The Coal
Authority

Re: Planning Application 2024/62/93474/W

Change of use from vacant industrial unit to 17 flats, including partial demolition: 35 St John's Road, Birkby, Huddersfield, HD1 5DX - 2ND RECONSULTATION

client	MR H CHAHAL		
project	RESIDENTIAL DEVELOPMENT 35 ST JOHNS ROAD BIRKBY HUDDERSFIELD HD1 5DX		
drawing	PROPOSED FLOOR PLANS		
revision	notes	date	drawn
scale :	1:100 AT A1	11.24	PB
project no.	2327	drawing no.	03

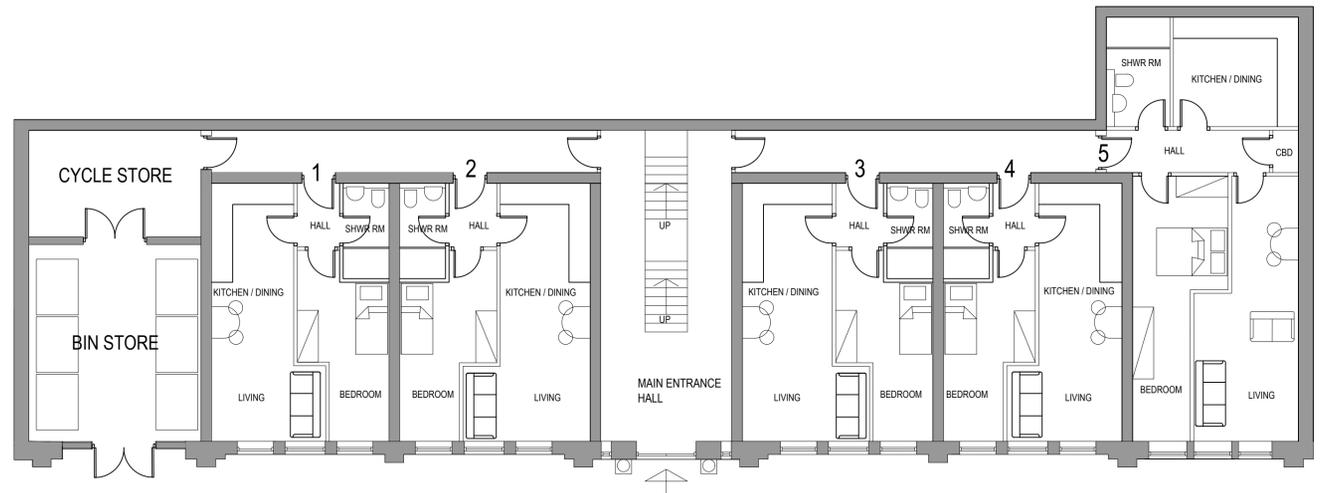
I have now reviewed the amended floor plans and note that the proposed development to the west of the site has now been superseded and has been replaced with landscaped communal areas with no new built development proposed. As such we note that the layout

of development has now been suitably informed by the presence of mine adit plotted within the southwestern corner of the site.

Nevertheless, we consider it prudent for ground investigations recommended by the applicants technical consultant to be carried out on the site in order to locate and confirm the condition of the mine adit plotted on site and to inform any remedial works and mitigation measures needed to ensure the site is safe and stable.

- 1. No above ground development shall commence until (excluding demolition of existing structures and site clearance);**
 - a) a scheme of intrusive investigations has been carried out on site in order to locate or confirm the absence of mine entry 414417-001; and**
 - b) any remediation works and/or mitigation measures to address land instability arising from coal mining legacy, as may be necessary, have been implemented on site in full in order to ensure that the site is made safe and stable for the development proposed.**
